WEST SUSSEX COUNTY COUNCIL CONSULTATION

TO:	Arun District Council FAO: Simon Davis
FROM:	WSSC – Highways Authority
DATE:	30 April 2026
LOCATION:	Land off Arundel Road Fontwell
SUBJECT:	WA/18/26/PL Erection of 64 residential dwellings with access off Arundel Road, together with associated parking, open space, play space, landscaping, drainage and infrastructure. This application is a Departure from the Development Plan, affects a Public Right of Way, may affect the setting of listed buildings and is in CIL Zone 3 and is CIL Liable as new dwellings.
DATE OF SITE VISIT:	n/a
RECOMMENDATION:	No Objection

Dwg. 33186-D-01 Rev. P1 land North of Arundel Road, Fontwell, Proposed Access

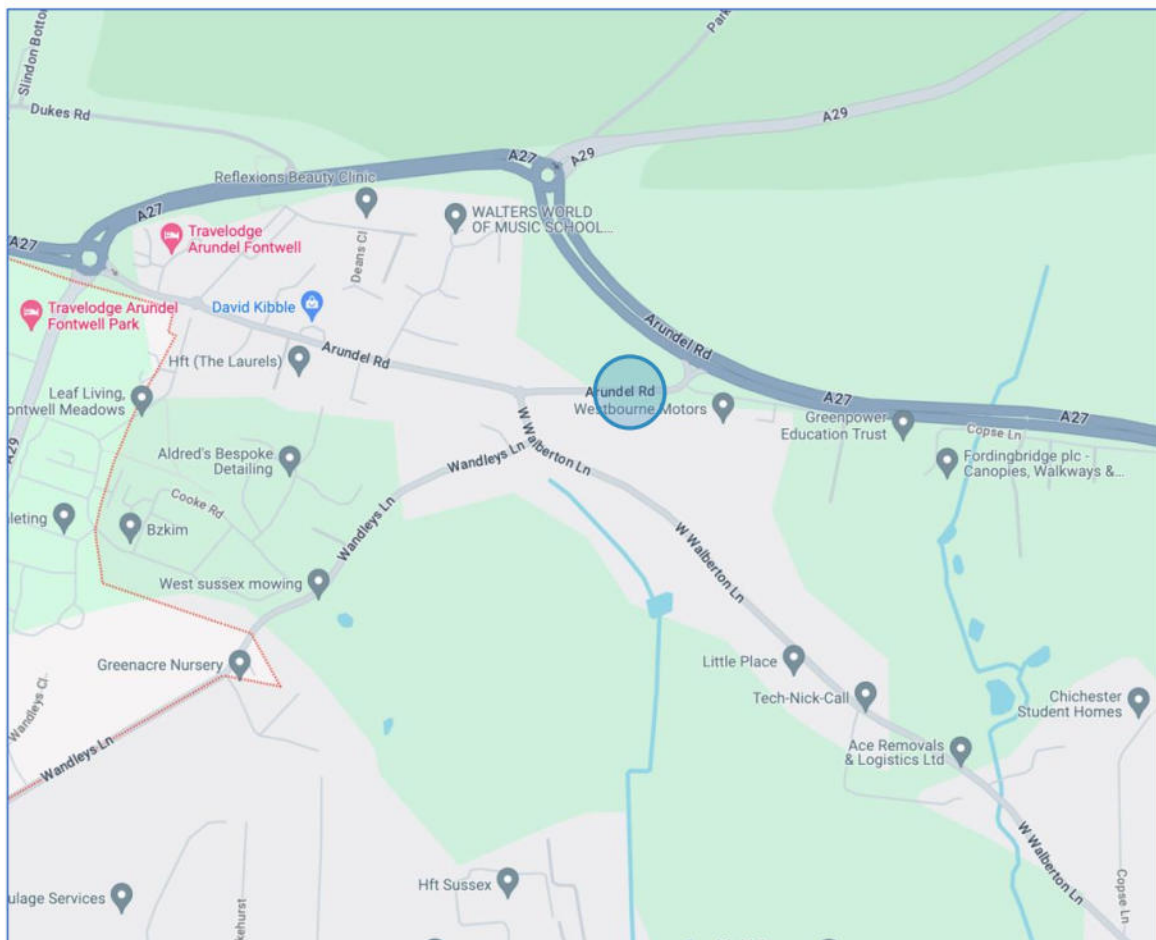
The scheme proposes a new bell-mouth priority access point onto Arundel Road with the main access road having a width of 5.5 metres. Traffic calming is present along the road in the form of speed bumps.

Speed surveys were undertaken on Arundel Road, which recorded 85th percentile speeds of 35.1 mph westbound and 35.3 mph, eastbound. Based on this, visibility splays of 53.6 and 54 metres are

required and provided. The proposed splays are in accordance with Manual for Streets (MfS) guidance for the speed limits recorded. The access works will be subject to a Section 278 Agreement and technical check with the LHA's Highway Agreements Team.

In terms of pedestrian access the new site access has a connection to footpath 2825 through the western boundary of the site. This provides an alternative walking route for pedestrians which would be off the carriageway. In addition, the new access has a footway 1.8 metre connection to the southern footways on either side of Arundel Road via tactile paving.
